Subject: 2021/90743

I have been having a final look at the above application

Title: Site Plan

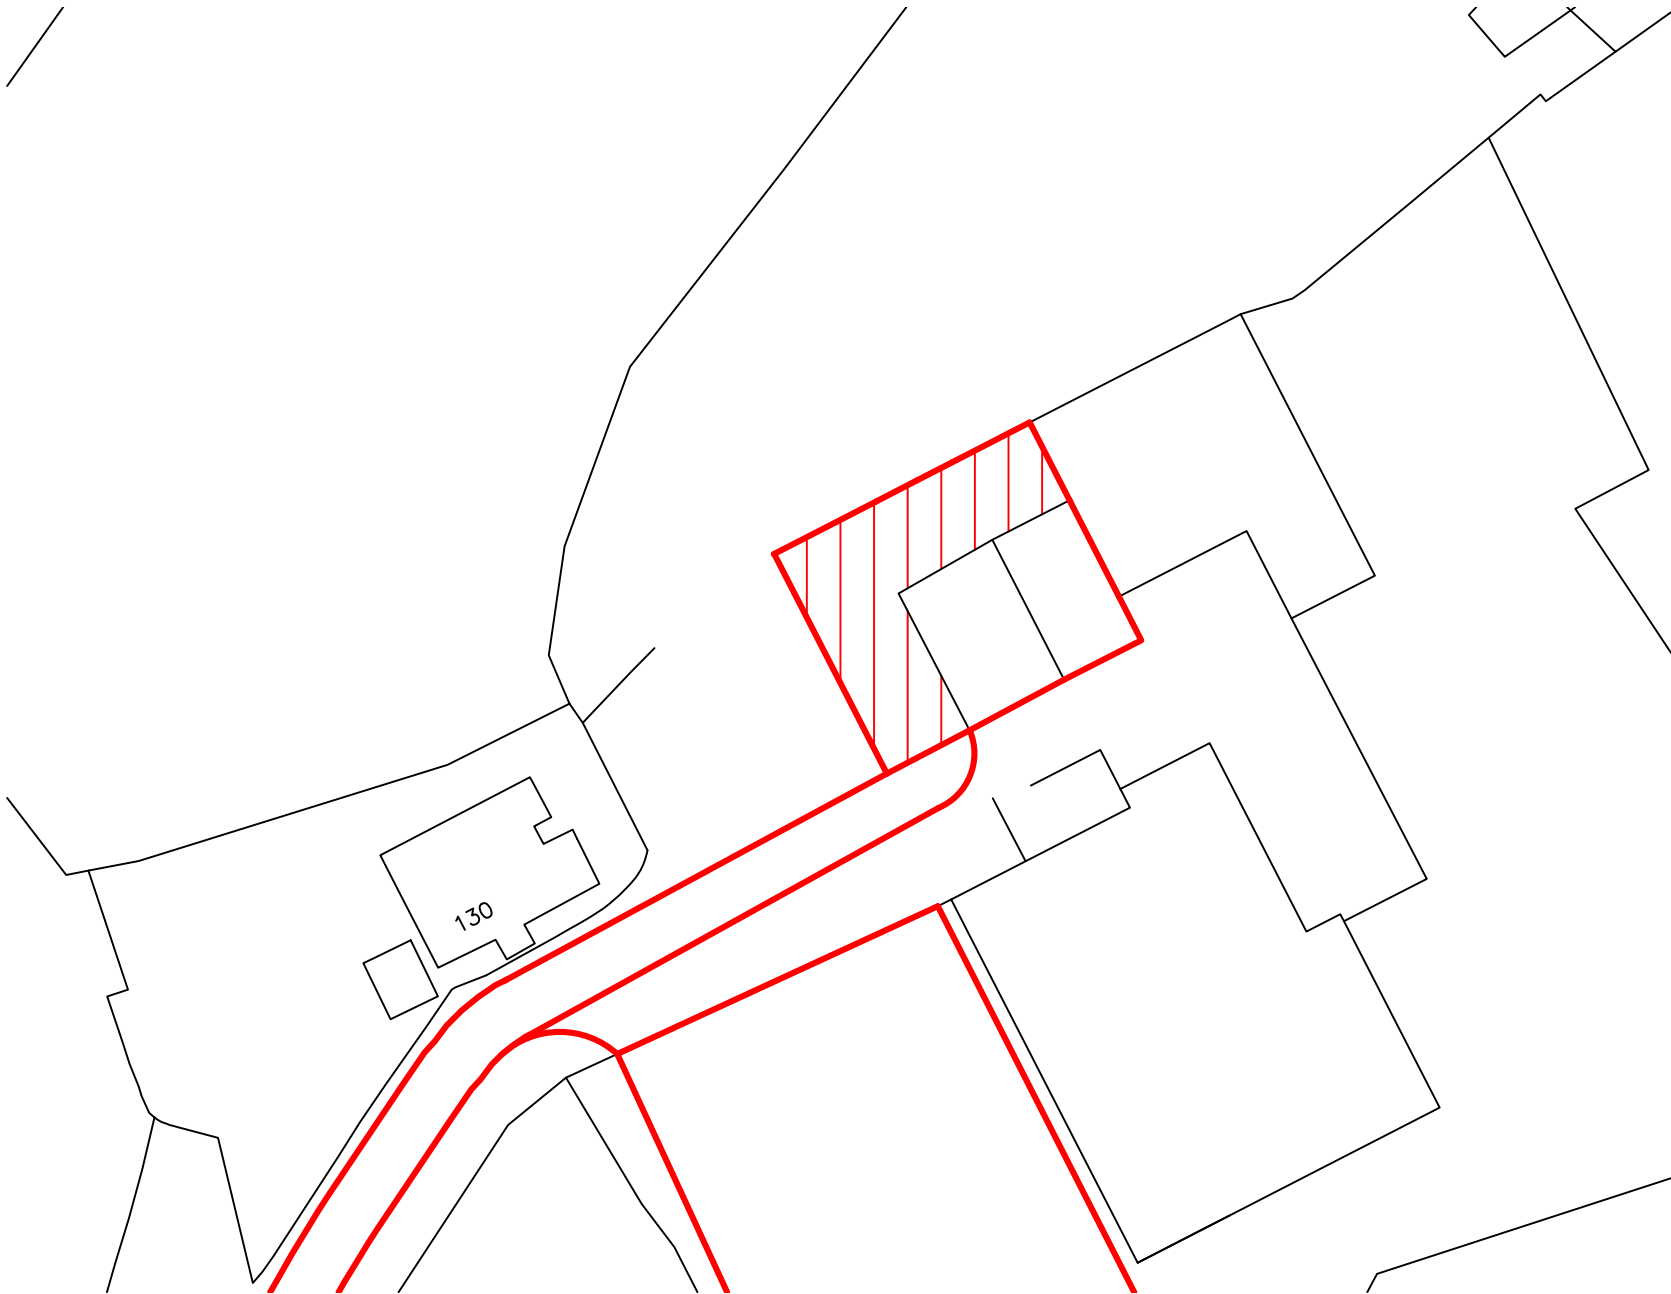
All the drawings show that the road has to be widened

If this is the case how wide does the access lane have to be for 2 vehicles to pass comfortably by each other

Can you also confirm this will be a pre requisite before opening of the cafe

On the application it states 8 parking spaces we believe that it has increased to 15
Highways stated a 90 sq m cafe would require in the order of 20 parking spaces
with a proposed floor space of 143 sq m surely the number of car parking spaces is
inadequate resulting in off site parking on the road on a bad bend near a junction
and a bus stop

Is this safe practice
